THE NATIONAL TRUST *of* AUSTRALIA (NEW SOUTH WALES)

RE: MP10_0048 - Headland Park and Northern Cove - Main Works

Barangaroo Headland Park - Main Works Application - Heritage Impact Statement – Final; October 2010 by Conybeare Morrison Pty Ltd

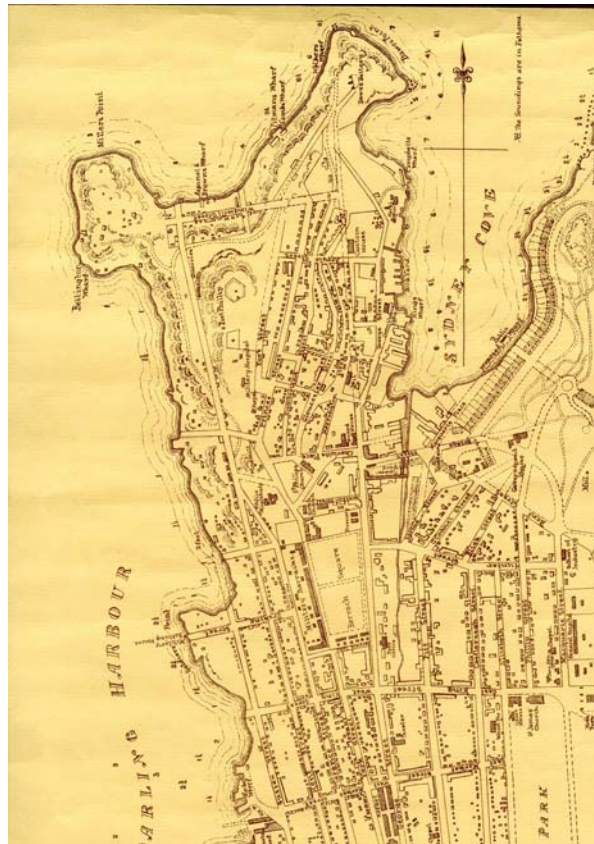
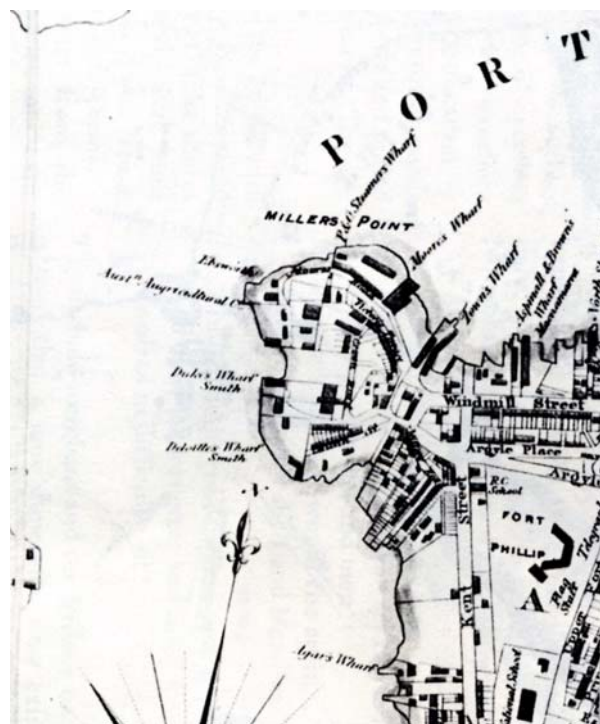
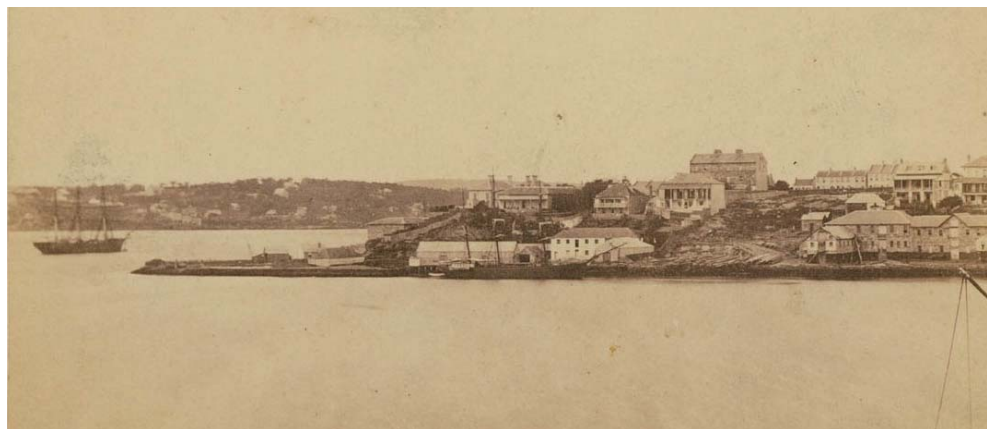
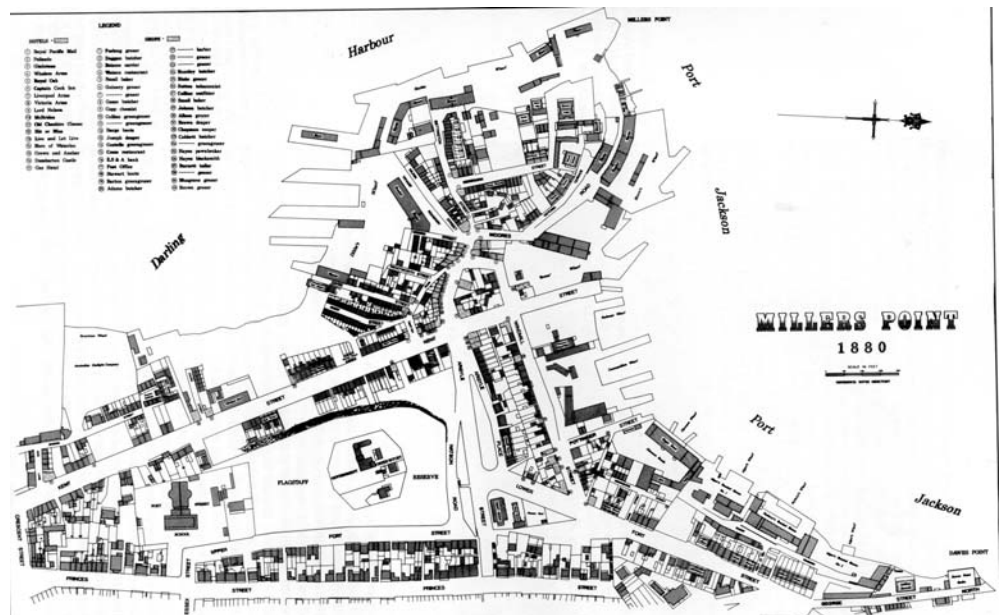
This latter statement is incorrect. Review of Figures 2.09, 2.10 and 2.12 demonstrate that the shoreline had been constantly modified, reclaimed and altered over the previous half century.

Fig. 6.1: East-West sectional drawing of proposed reconstructed landform, cultural centre and carpark. (Source: Barangaroo Delivery Authority)

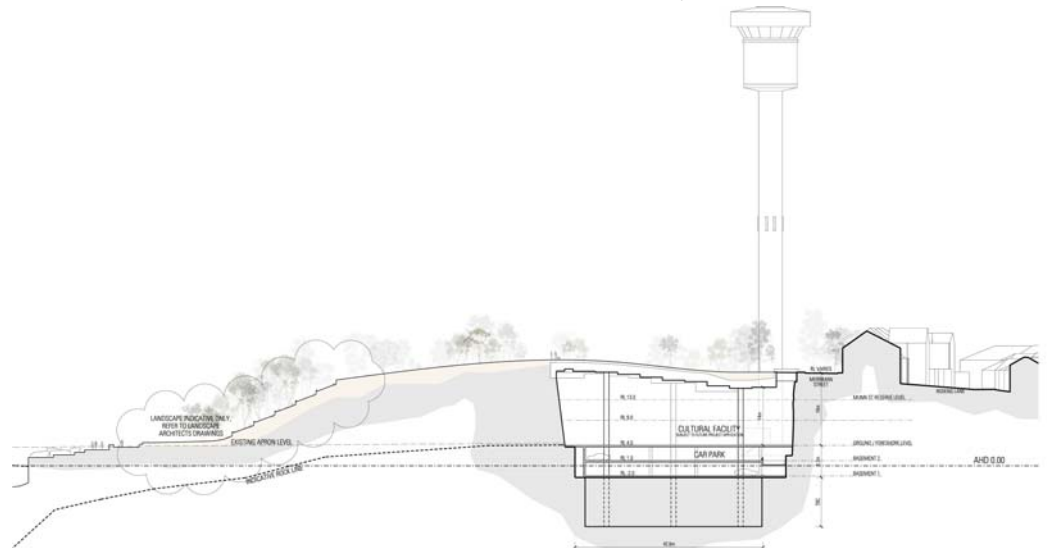
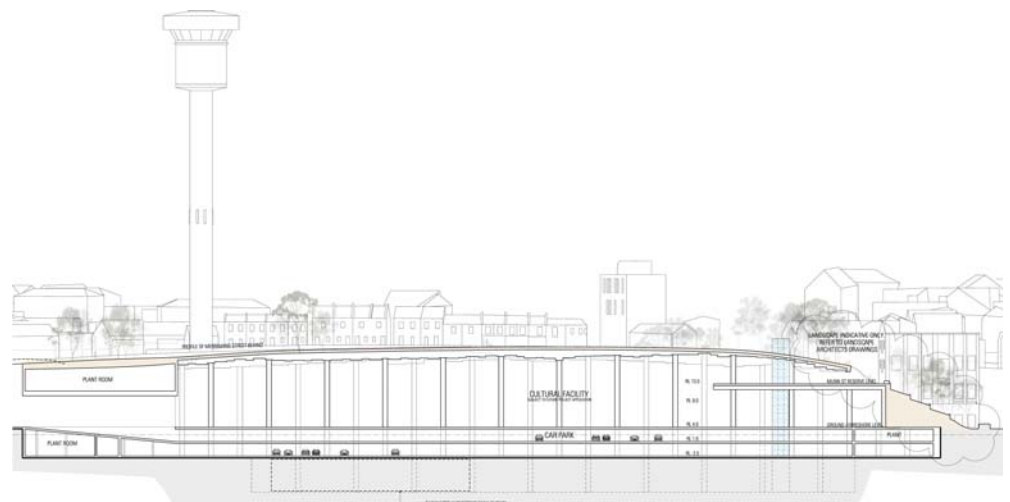
This is the most egregious example of sophistry in the assessment of heritage impact. The cliff will be entirely concealed to all viewpoints except that from directly above (or from within the underground car park) and to suggest that the remnant narrow 'fissure' represents the "*subtle retention of industrial evidence*" is just ridiculous.
